The Member Secretary
Chennai Metropolitan
Development Authority,
No. 1, Gandhi Irwin Road,
Egmore, Chennai-600008.

Letter No. Bc/1218/05

Sub: CMDA - Area Plans Unit - Planning Permission - Proposed construction of
G+P+3 floors residential building with 7 sets of old door no 1,
New no 1, 79th Street, 18th Avenue, Ashok Nagar, Chennai-8,
Composed in T.S. no 61, Block 52 of Kodambakkam village -
Permitting of all other charges - P.P. Plan.

JOB TITLE  
PLAN SHOWING THE PROPOSED ADDITIONAL CONSTRUCTION OF A RESIDENTIAL BUILDING AT OLD DOOR NO 1, NEW NO - 1, 79TH STREET, 18TH AVENUE, ASHOK NAGAR, CHENNAI - 600083, COMPRISED IN T.S.NO. 61, BLOCK NO. 52, KODAMBAKKAM VILLAGE, OF CHENNAI DISTRICT, ZONE - 8, DIV - 122

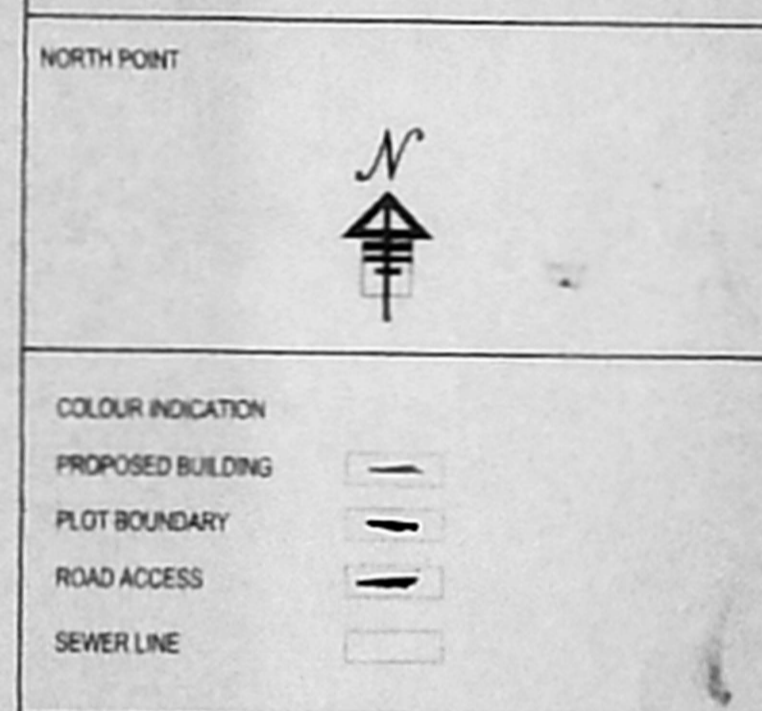
b) you are also requested to furnish revised plan showing cross section on 44' correctly in scale 1:100.
